# Thurrock Power Ltd Comments on Natural England Procedural Deadline D Submission

## Deadline 2

## 1 INTRODUCTION

Figure 4.1: Construction – Causeway construction in Zone G.

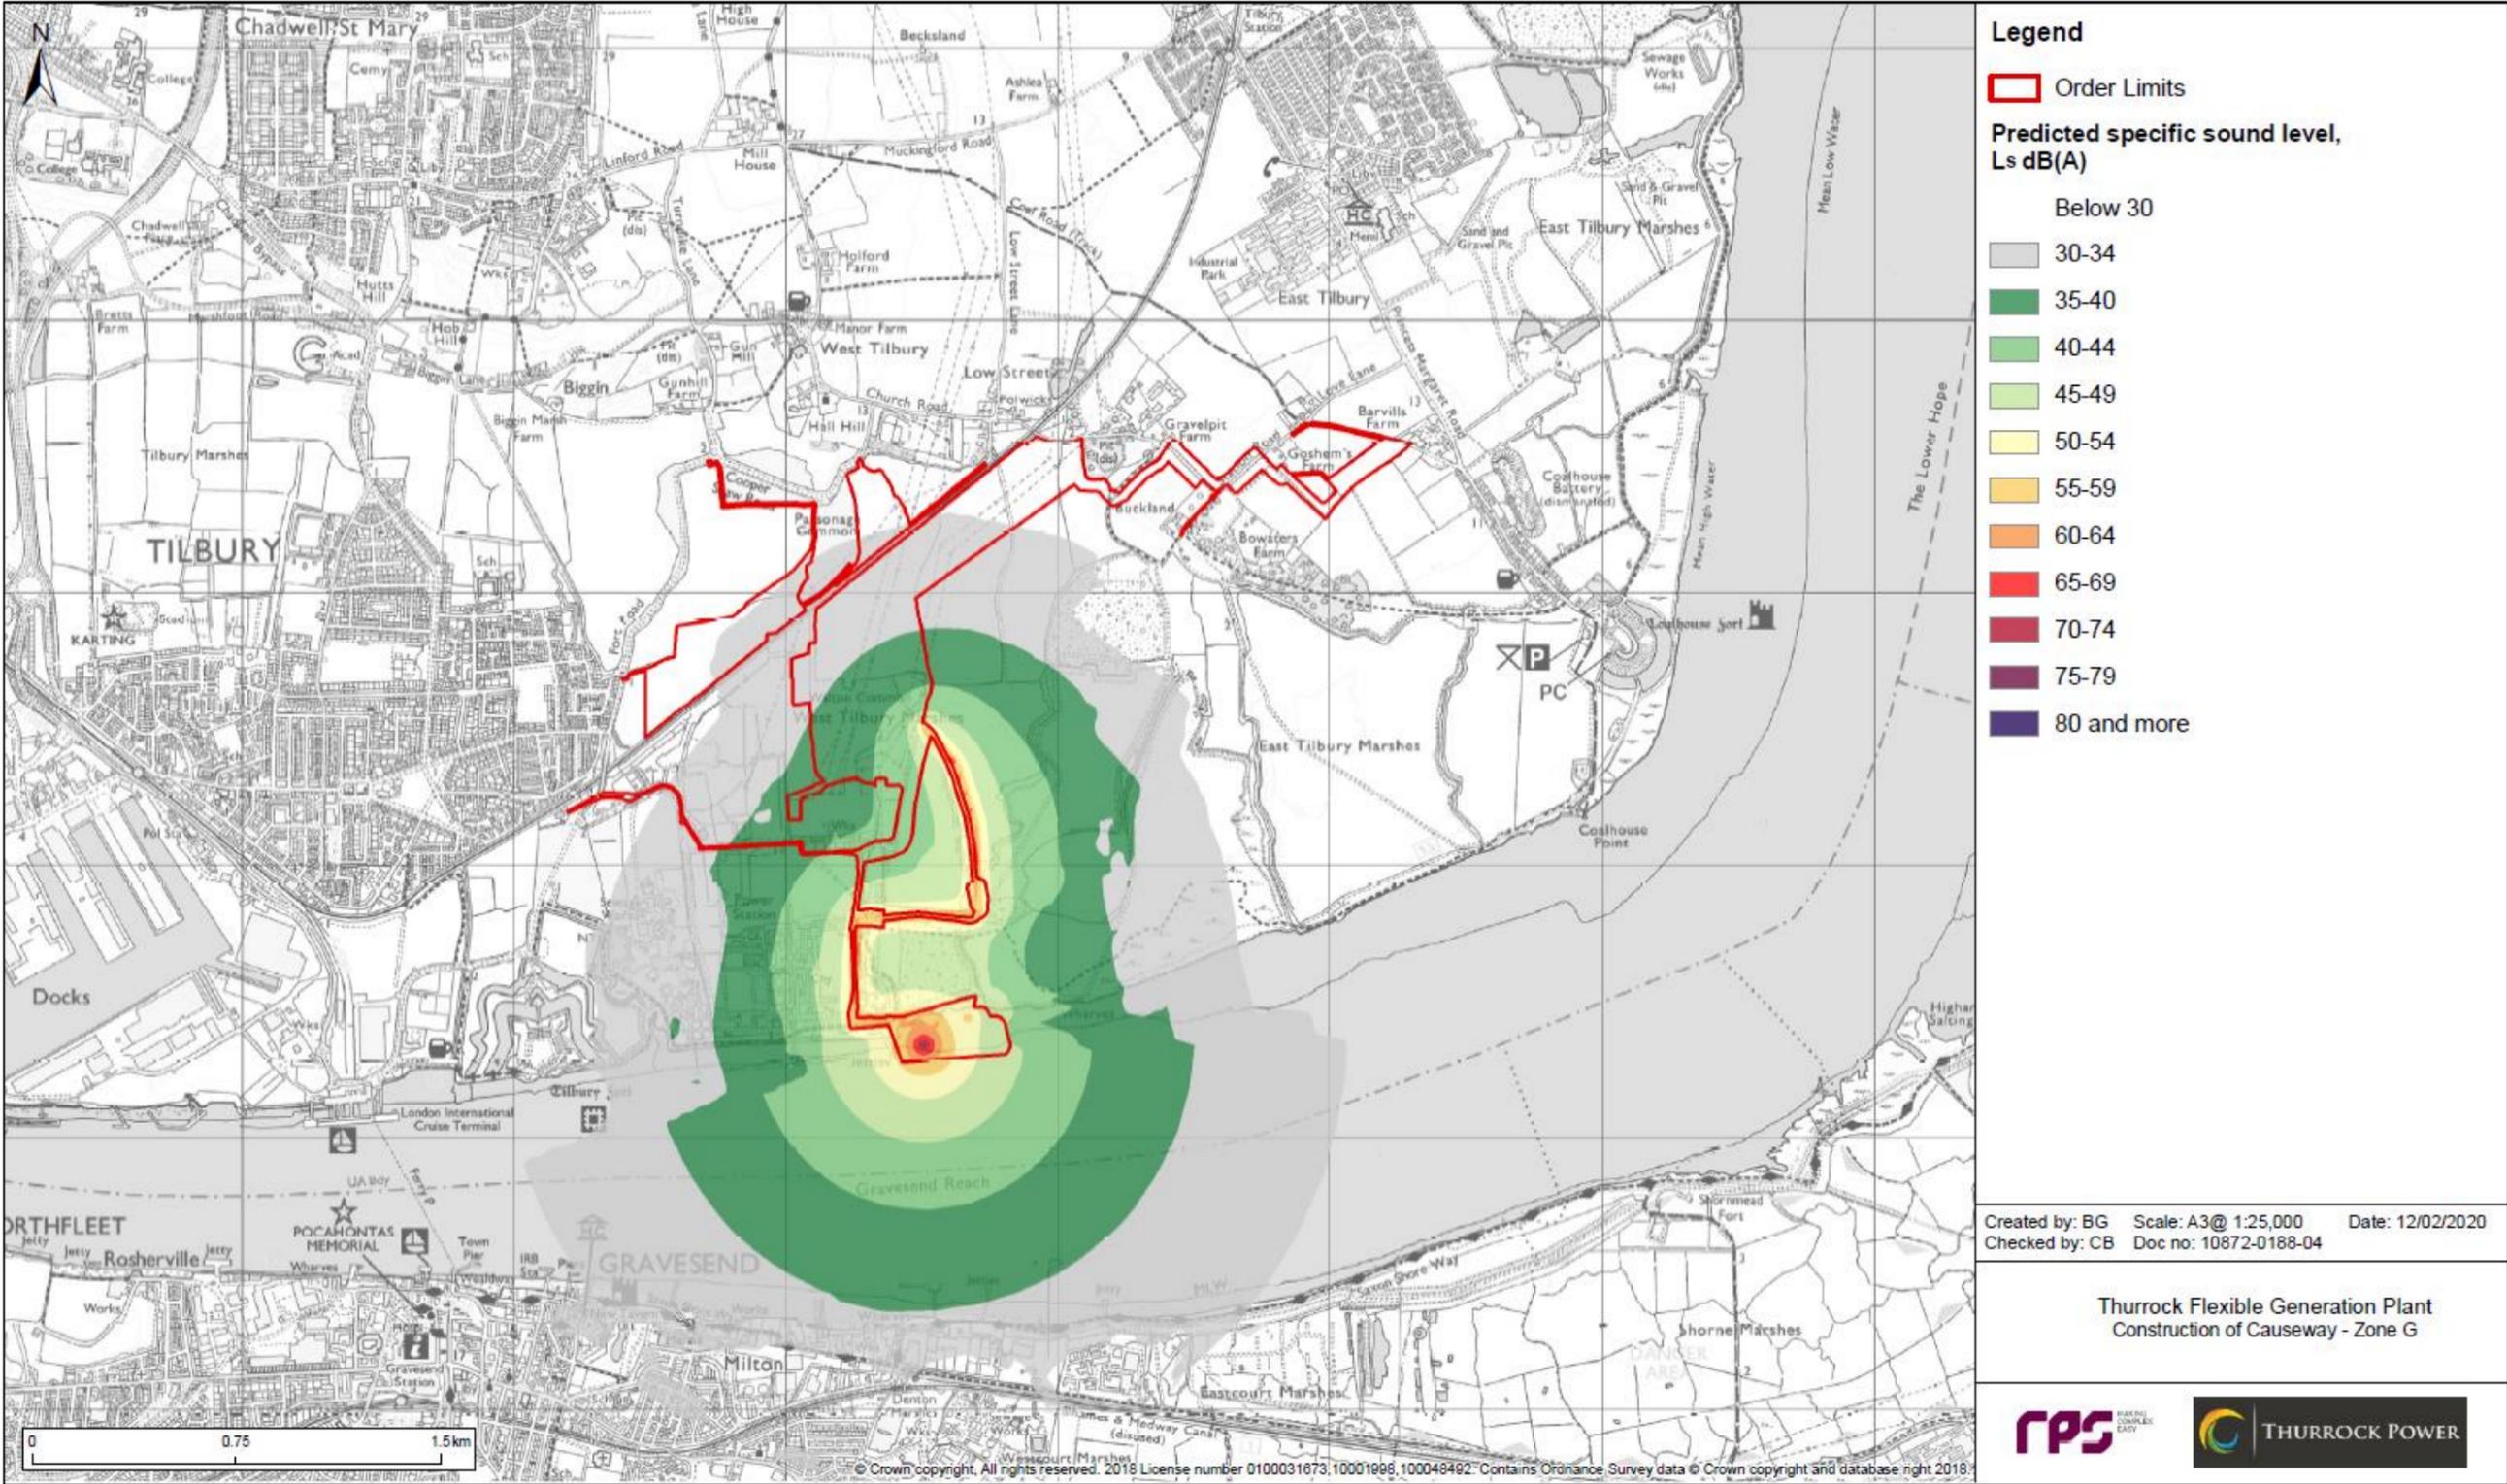
Subject		Number	Comment in PDD-012	Thurrock Power Ltd Response
			out in paragraph 6.4.66. We suggest that a REAC commitment could be worded to commit the developer to preferentially avoid the most sensitive months, alongside the other measures described.	
	Construction phase use of the causeway	1d	We note the sequencing of events proposed and the flexibility sought around the phasing of batch deliveries. Again, in our opinion REAC commitments could be worded to commit the developer to preferentially avoid the most sensitive months.	See response to 1c above.
	Operation Phase Retention of the Causeway	1e	The causeway is proposed to be retained for the life of the project (design life 35 years). As described above, our preference is that the losses described are set within a more local context (i.e. component SSSI), and that as a result the direct medium-term loss of available habitat should not be screened out from Appropriate Assessment (ref. paragraph 5.1.20).	We refer back to our previous response (1a) on the appropriate scale at which impacts on SPA birds should be assessed.
